DEVELOPMENT REVIEW BOARD

Parks and Recreation Department

PR-2021-005573

REQUEST: AN APPROXIMATELY 117.53 ACRE EXPANSION OF THE EXSITING ALBUQUERQUE STUDIOS CAMPUS INCLUDING A NEW PRODUCITON OFFICE, MILL BUILDING AND PRODUCTION SUPPORT SPACES.

SHEET NO.
SDP 2.4

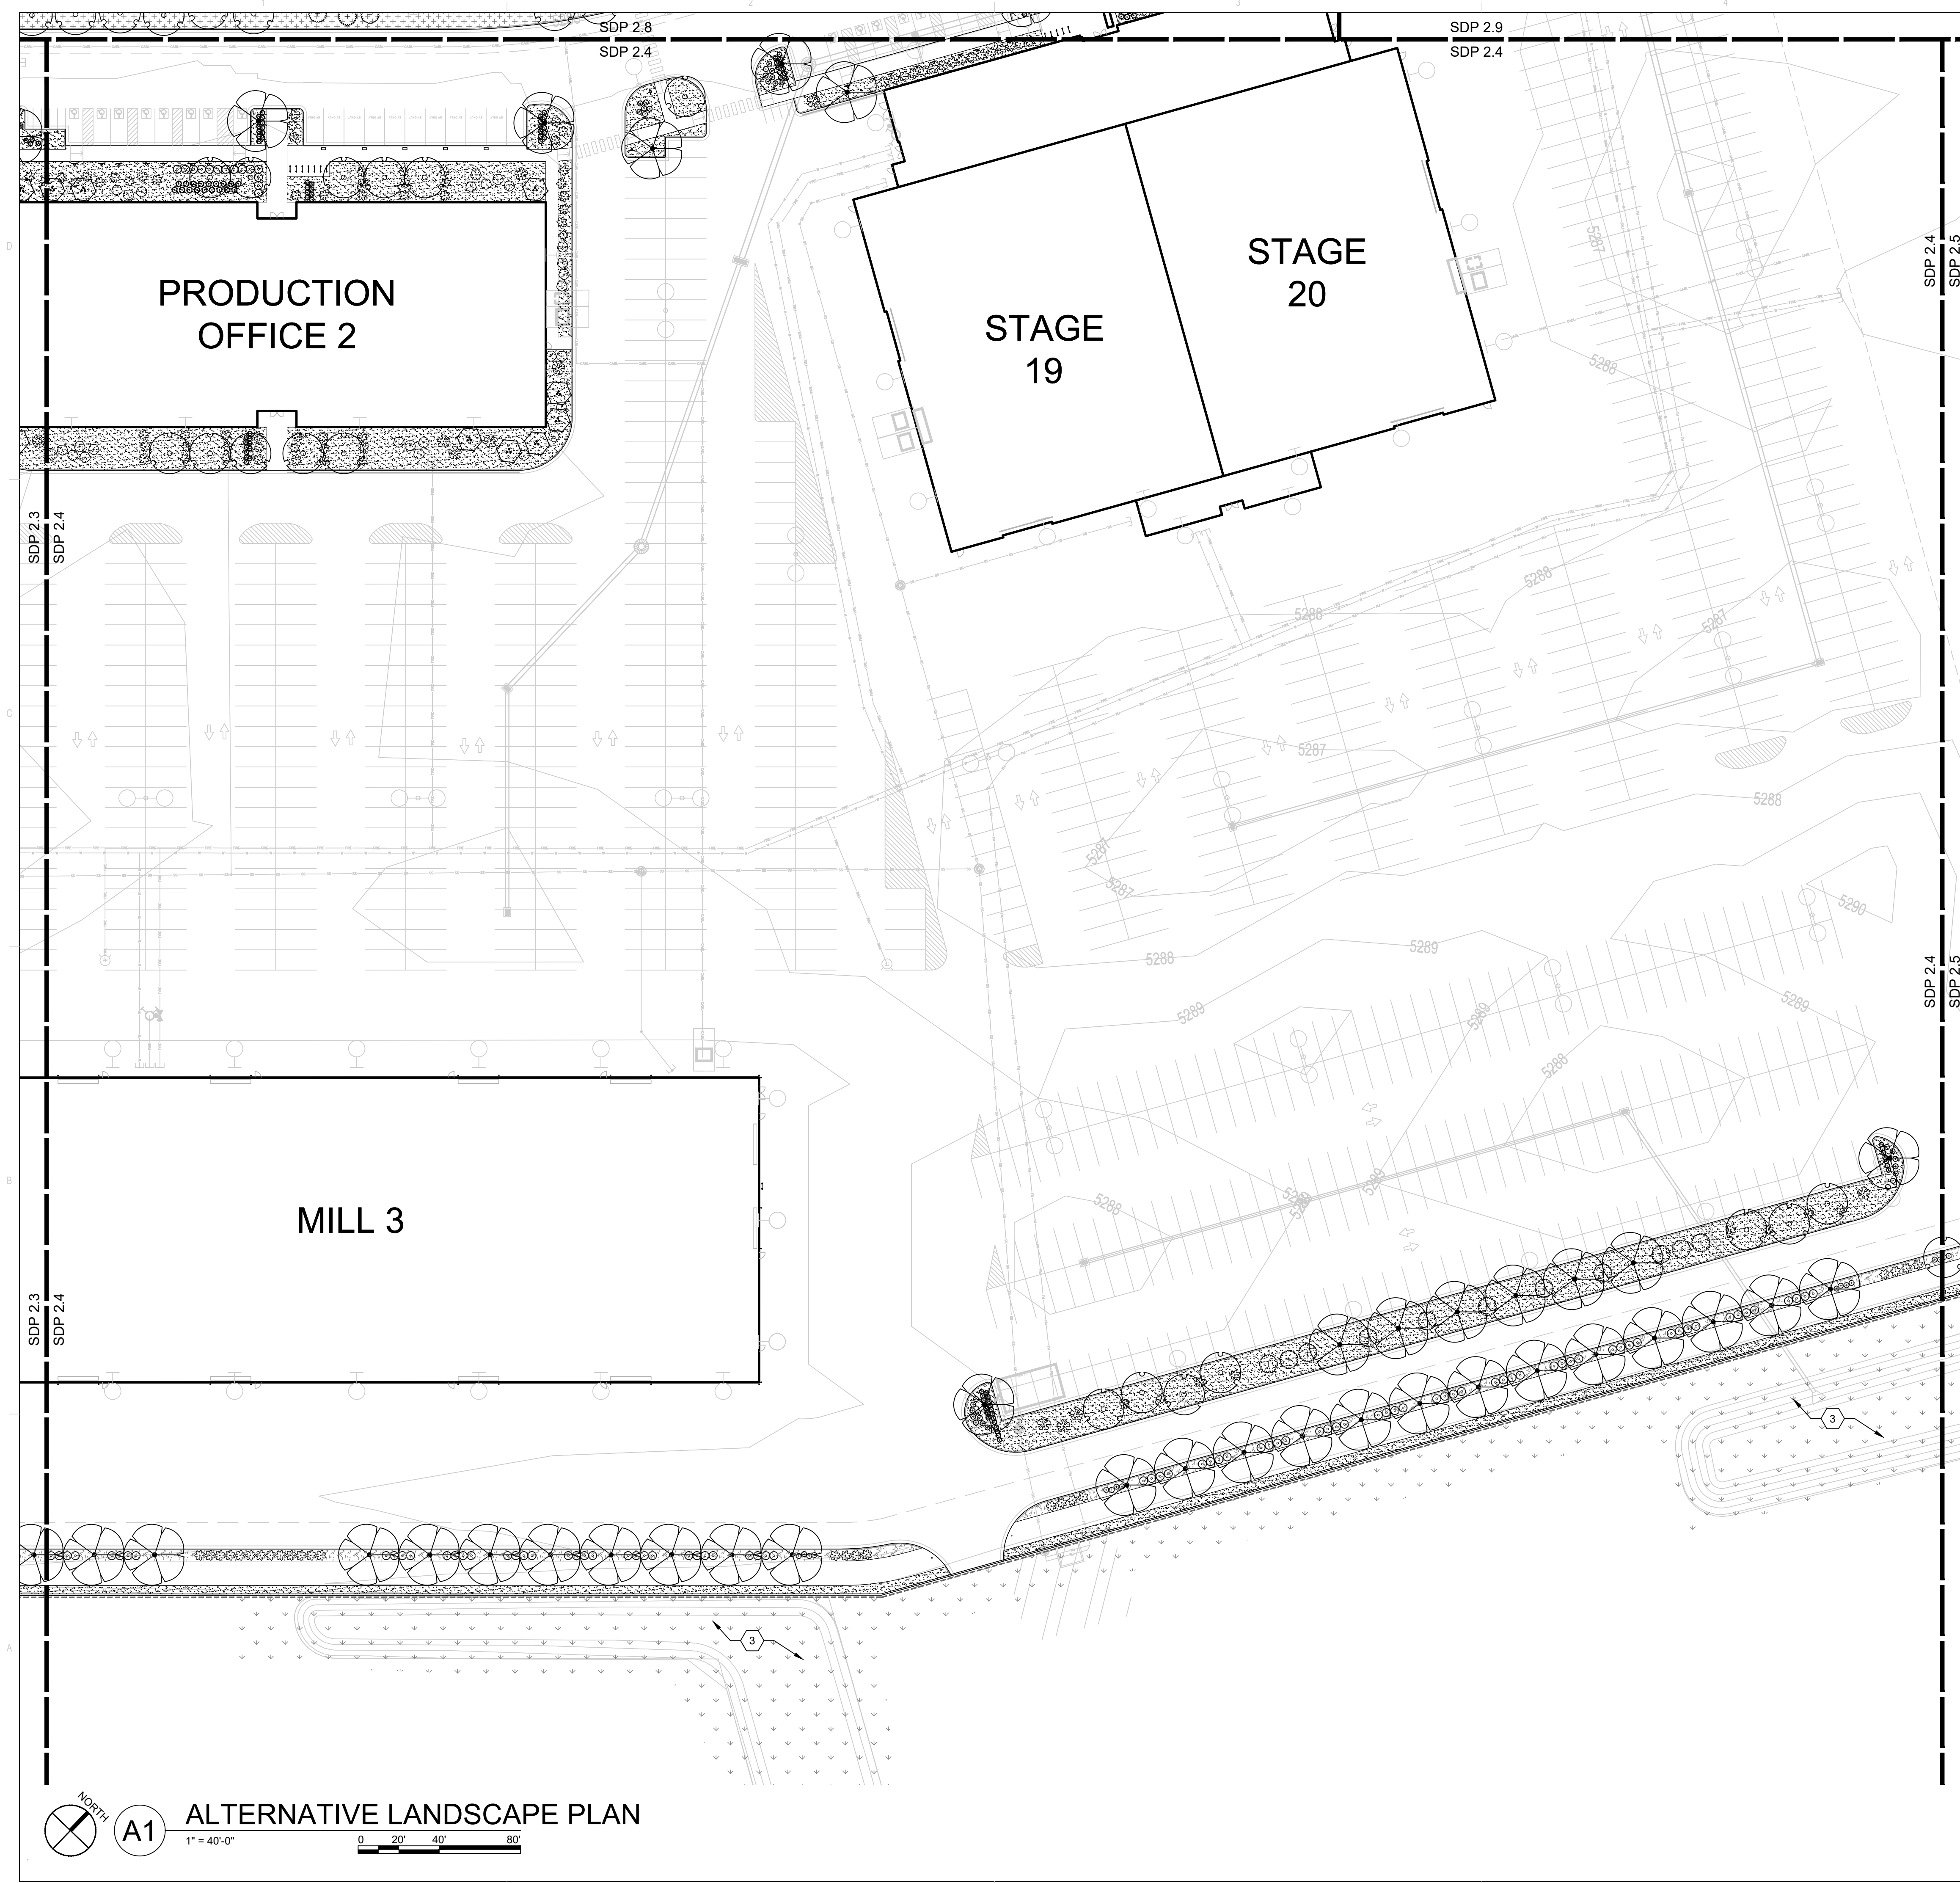
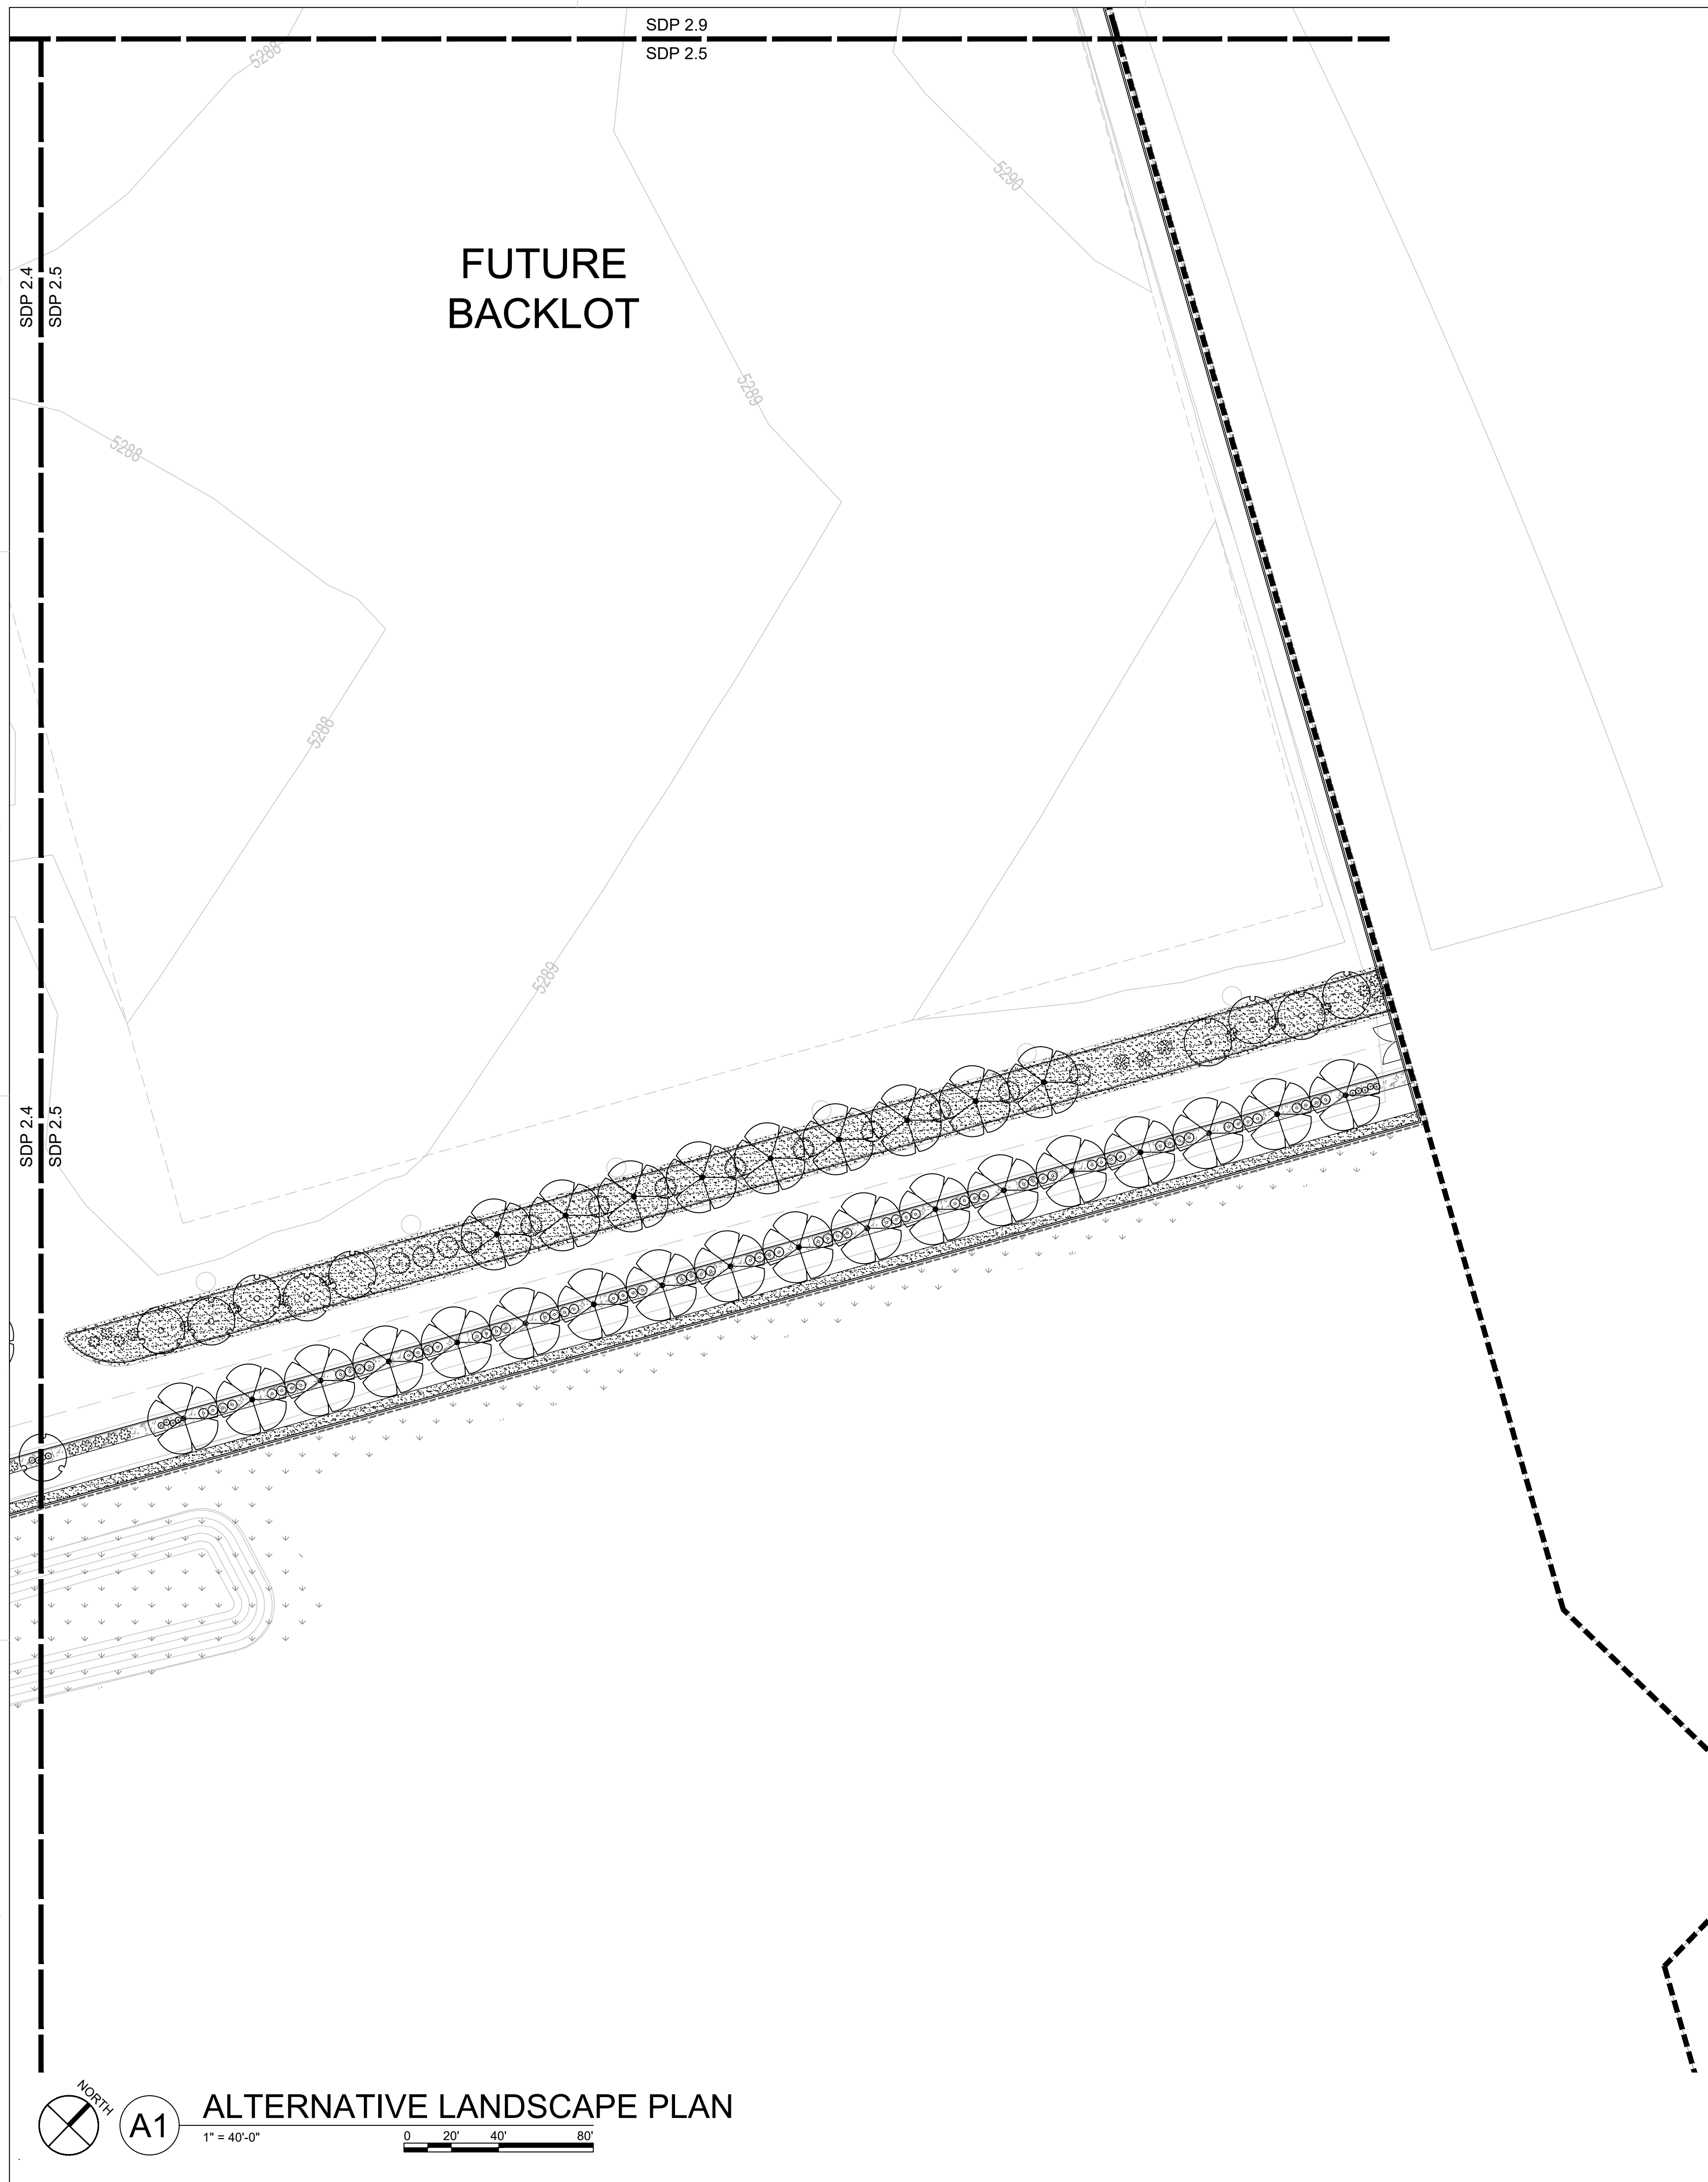
Is the plant pallet derived from a Mesa del Sol list? – if so, please provide referenced master list and/or page along with list for native seed mix. Where rock mulch used, please provide note regarding wood mulch for trees per 5-6(C)(5)(e).
